30th November 2020

Application No: EP/124/20/HH
Site Address: Little Dormers 23 Upper Drive East Preston BN16 1QN
Description of works: New bay and porch skirt roof to the front elevation, and roof linked detached double garage.

Thank you for your internet representation made on 27th November 2020 which has been recorded as an objection with the comments as follows:

Location Plan and Block Plan

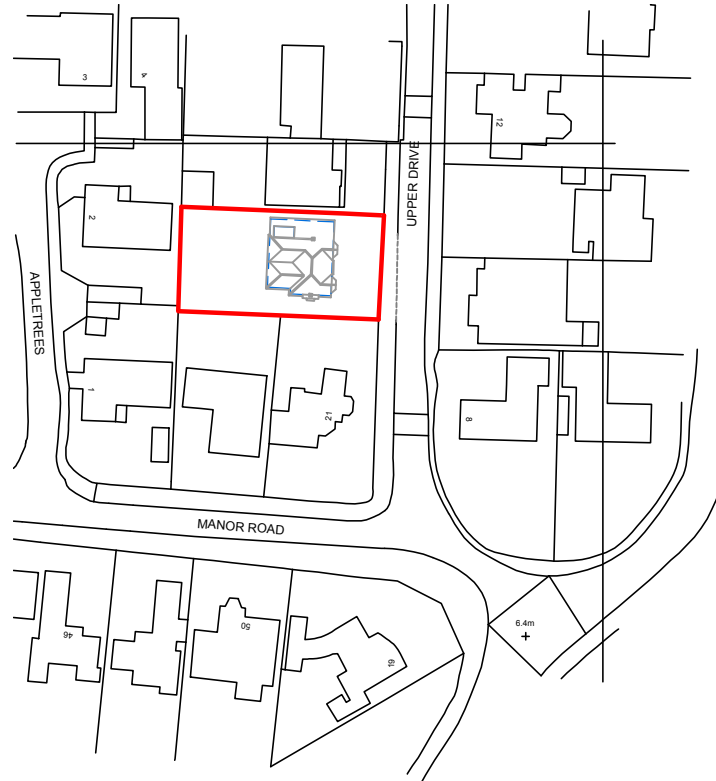
1. The street scene is unquestionably one where the main front walls of all the present buildings in the road largely lie behind roughly 8 metre deep front gardens. Once the garage is built it will ruin this open appearance as it will reduce the front garden depth for a large part of it to just over 1 metre. This would be a very negative result.

Garage Plans and Elevations -
Proposed

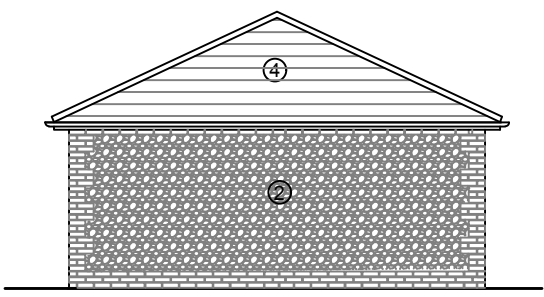
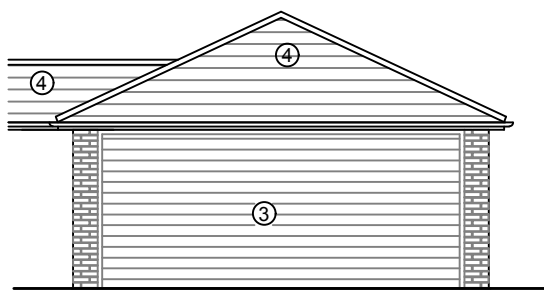
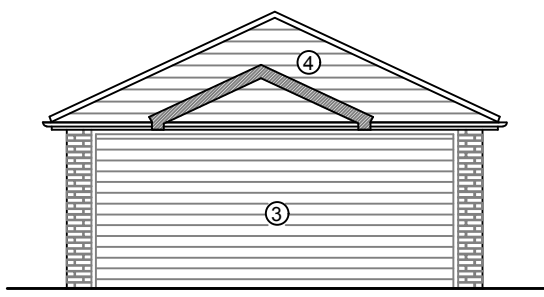
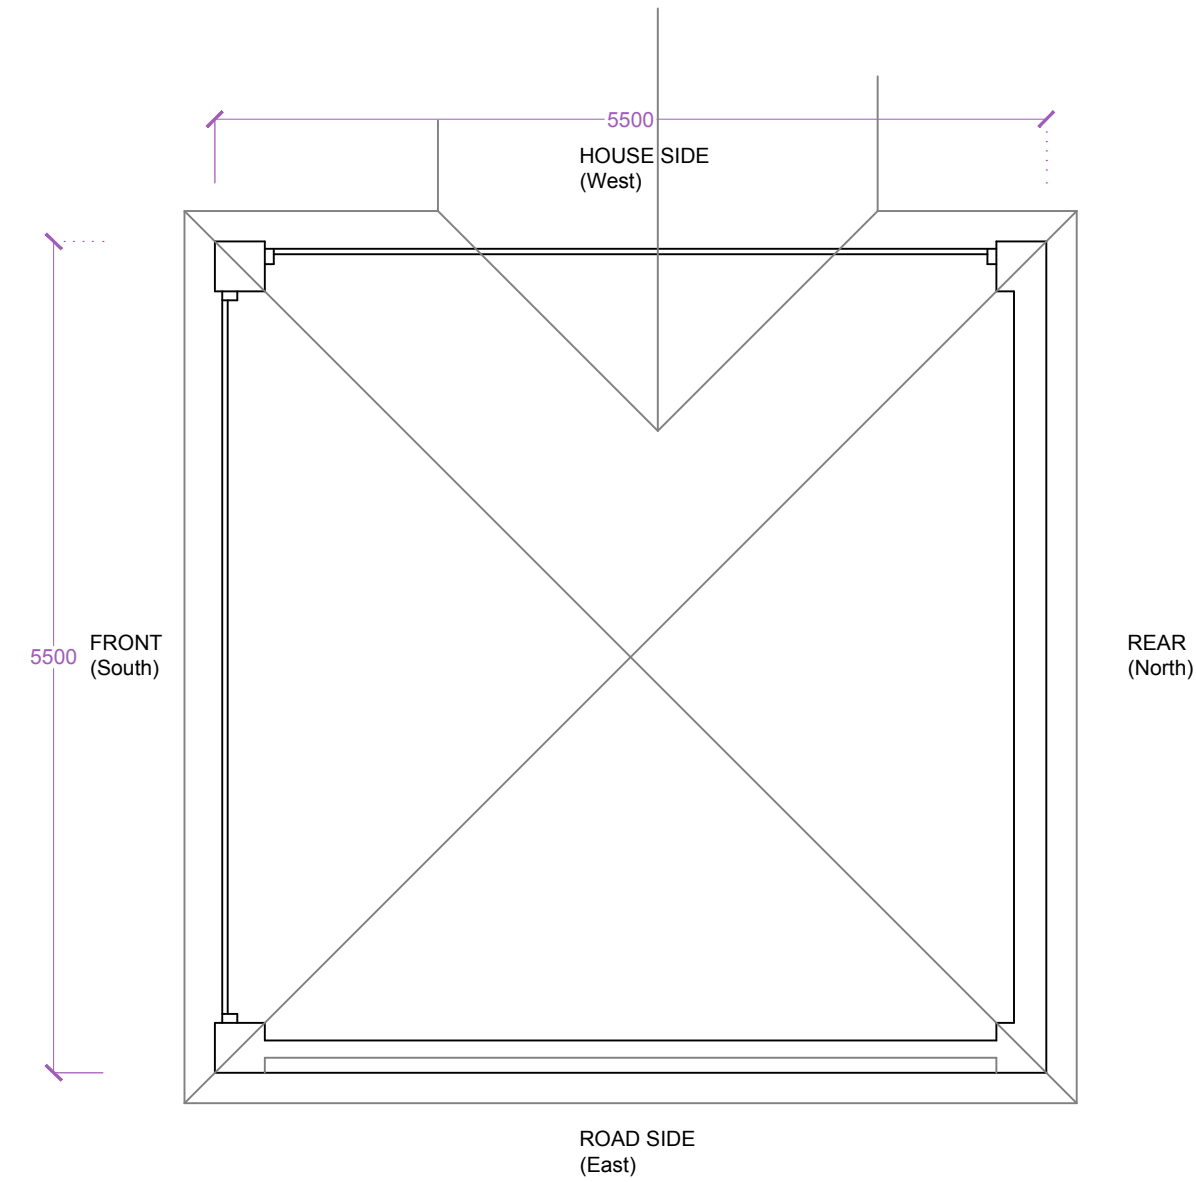
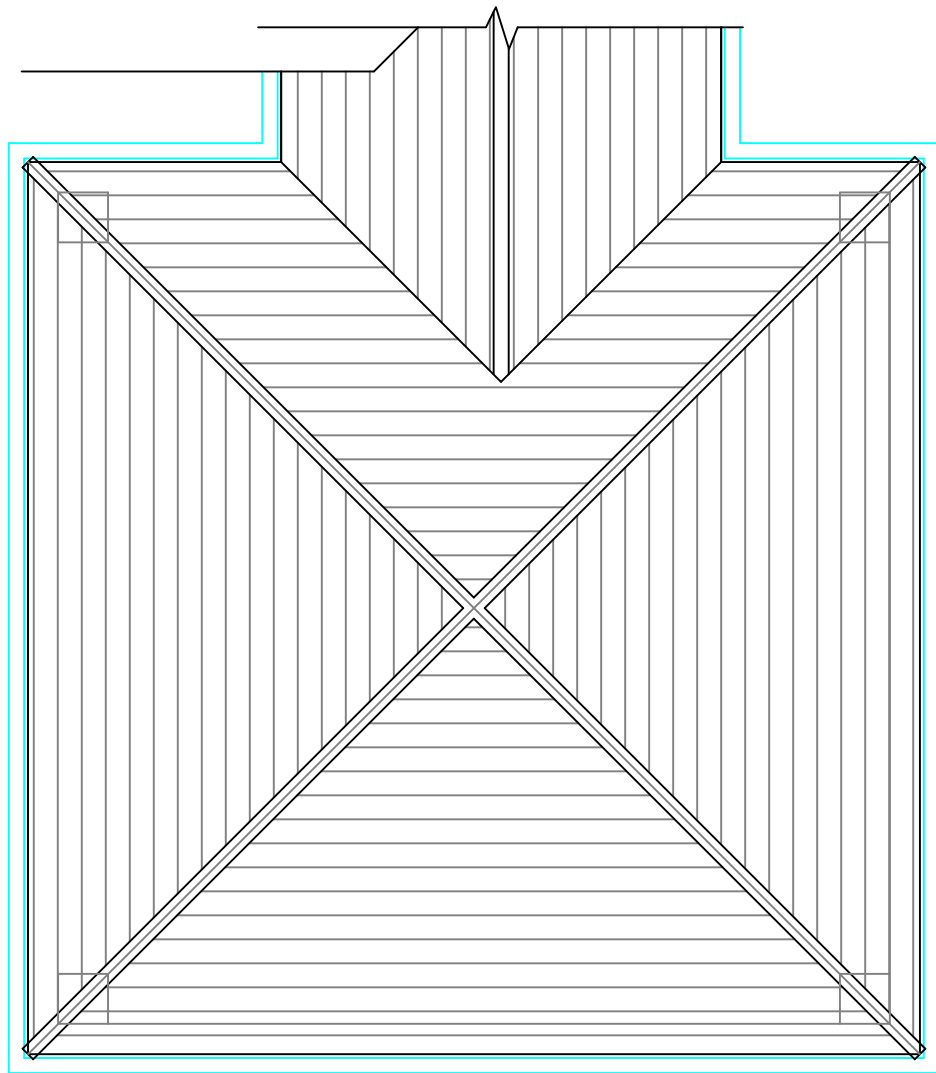
2. Any extension to a property ought to be subservient to the existing house. This garage will not be. It will be like a huge carbuncle and a dominant feature in the front garden which should remain open as with the other properties on this side of the road.

3. The garage will be built only 500mm away from the northern boundary of the property. The overhang including the guttering will be even less. This will not allow the building including the eaves gutters to be properly maintained without encroaching upon the property to the north. Has consent to encroach been obtained? A building that cannot be properly maintained may become an eyesore.

4. The height of the proposed garage is such that it will cut out light to the house to the north and also

overshadow part of it.
